Thank you for the below questions addressed to Historic England as part of EXQ1.

We note your authority would like a response from Historic England in regard to Q11.0.2, Q11.0.3 and Q11.0.4.

FIGURE 13: ASSETS CONSIDERED IN ES

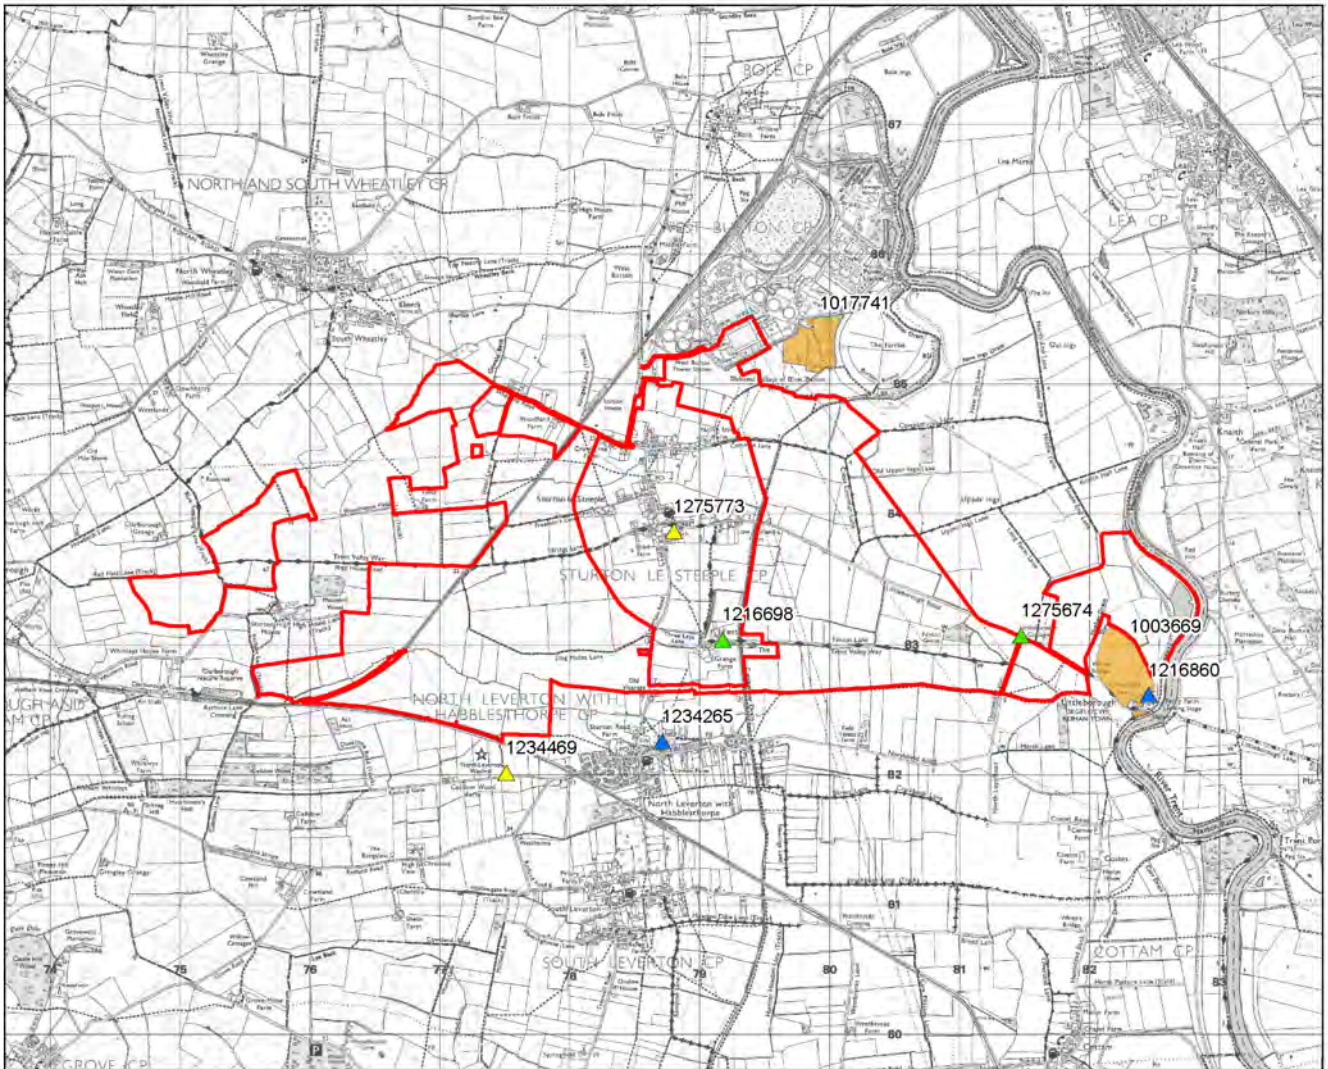
Firstly, we note and acknowledge the existing set back (by 1 field) of the infrastructure from the windmill. However, in terms of the assessment of the impact to the significance of the windmill via change in its setting, we consider that the applicant has applied a rather reductive approach in only considering the significance derived from the design intent. We consider that North Leverton Windmill not only derives significance from its design intent, but also the kinetic views that are experienced on approach to and from the asset, observable and readily appreciated in both short and long ranging views. Despite modern built form that has subsequently been added to the landscape, the windmill can be understood in its agricultural setting, as it would have been historically.

Historic England suggest development as proposed would result in a moderate level of less than substantial harm to the significance of the highly graded asset as a result of change in its setting. We consider that further detailed visual assessment may be helpful, including further visualisation.

Many of the photos and montages show the tower quite clearly in long ranging views, and the introduction of the panels entirely obscures this view from certain ground level views, which as identified above would present, what we would consider a moderate level of less than substantial harm to the significance of the highly graded asset as a result of change in its setting.
